WEST SUSSEX COUNTY COUNCIL CONSULTATION

TO:	Arun District Council FAO: Mrs. A. Gardner
FROM:	WSCC - Highway Authority: Tim Townsend
DATE:	15th October 2019
LOCATION:	Land At Toddington Farm North And West Of 1 To 3 Toddington Toddington Lane Littlehampton BN17 7PN
SUBJECT:	LU/295/19/DOC Approval of details reserved by condition imposed under ref APP/C3810/W/18/3197149 (LU/162/17/PL) relating to Condition Nos 9 - landscaping, 10 - Construction Management Plan, 13 - vehicular visibility splays, 14 - pedestrian visibility splays, 16 - cycle parking and 18 - street lighting.
DATE OF SITE VISIT:	n/a
RECOMMENDATION:	Advice/More Information/Modification
S106 CONTRIBUTION TOTAL:	n/a for purposes of this DOC application

This is the WSCC County Highways (CHA) response to the above planning application for approval of details reserved by condition imposed under ref APP/C3810/W/18/3197149 (LU/162/17/PL) relating to Condition No's 9 - landscaping scheme, 10 - Construction Management Plan, 13 - visibility splays, 14 - pedestrian visibility plays, 16 - cycle parking and 18 - street lighting.

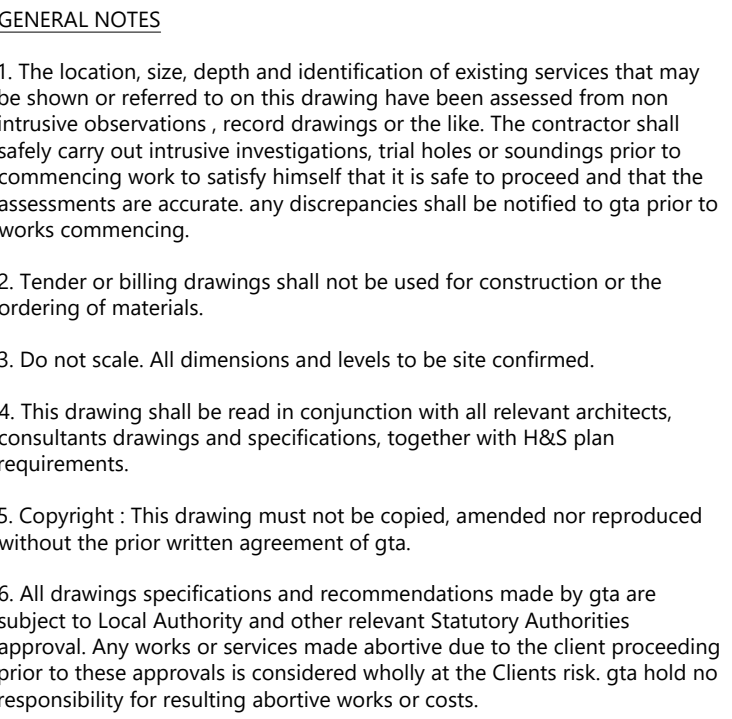
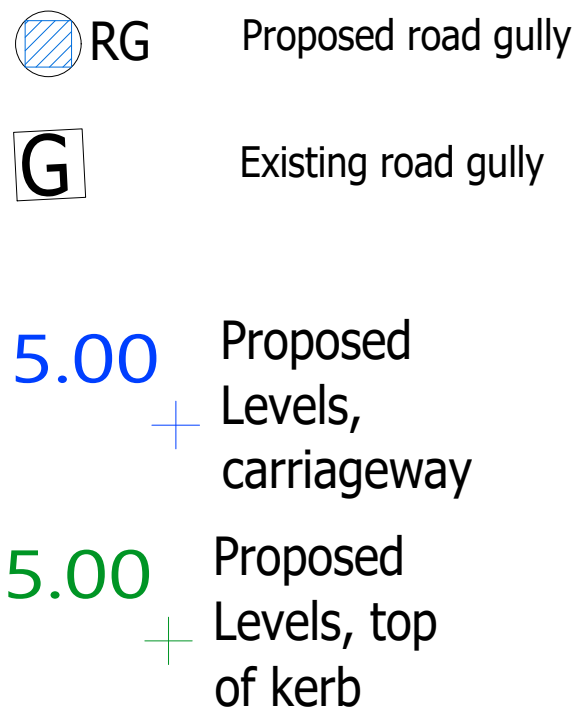
Stopping-Up of highway – As documented previously, parts of the proposed steps, ramp and 'internal' footpath are shown on land which is publicly maintained highway. WSCC would not accept these on highway land. Therefore, formal Stopping-Up of highway would need to be secured by the applicant prior to any works commencing on any land currently forming part of the public highway and any land having impact upon it. Likewise, S38/278 works may not be approved (and could not start) until the Stopping Up Order is confirmed. Details of the Stopping-Up and S38/278 processes can be made available by contacting WSCC Legal Services Team. Also, if any structures are required (on highway land) to support the aforementioned ramp and internal access paths etc., these would have to go through a detailed WSCC (AIP) checking process.

Detailed Planting Plan

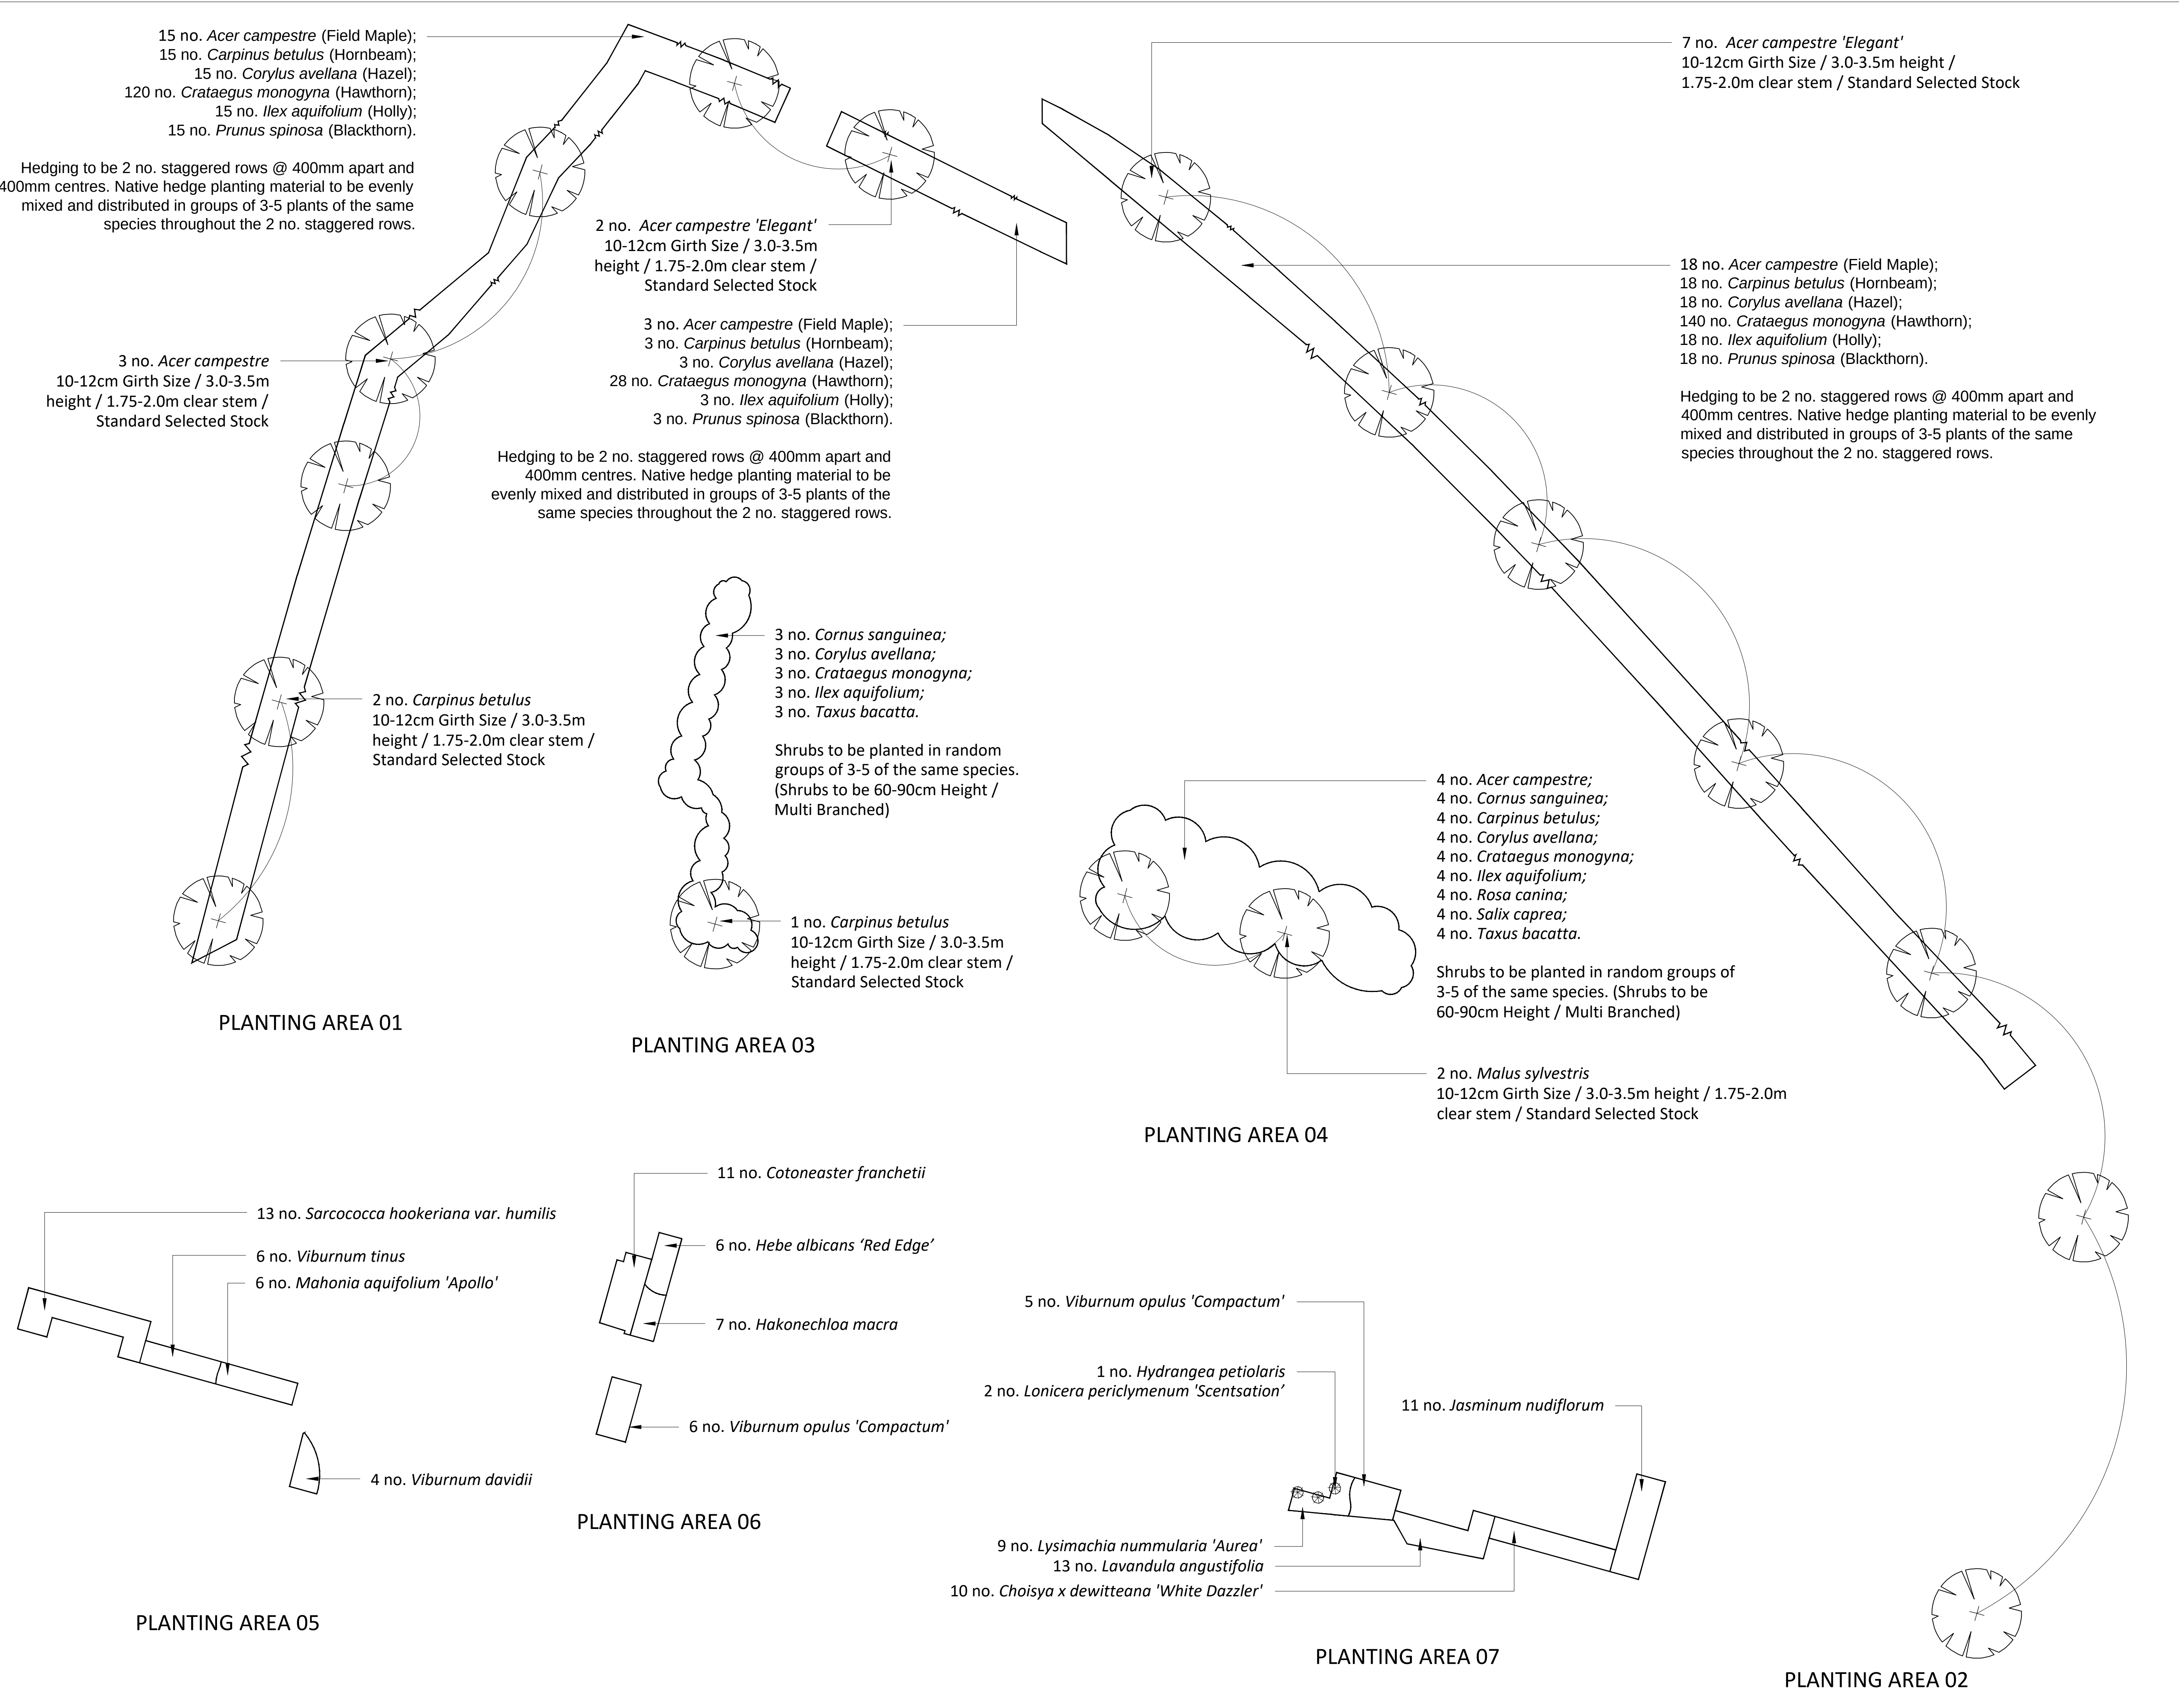
1. *Condition 9 (landscaping)* – The proposed hedgerow planting alongside Toddington Lane would be planted using 60-90cm transplants – almost a metre in height already – but it is stated in the management plan [paras 2.3.13/14] that it would be maintained at a height of 1.2m. At this height it wouldn't provide any screening to/from the development, nor would it be much of a rural countryside hedge feature in the street scene. However, from a highway point of view, it would obstruct pedestrian/motorist intervisibility (see further comments below). It would also be subject to frequent trimming to keep the height low and is unlikely to develop the density to provide good habitat.

An alternative approach might be to retain and/or plant suitable trees, but plant the hedge at the top of the bank or partially on the slope, if feasible, and doesn't conflict with anything else. Please amend alongside comments below about visibility splay requirements.
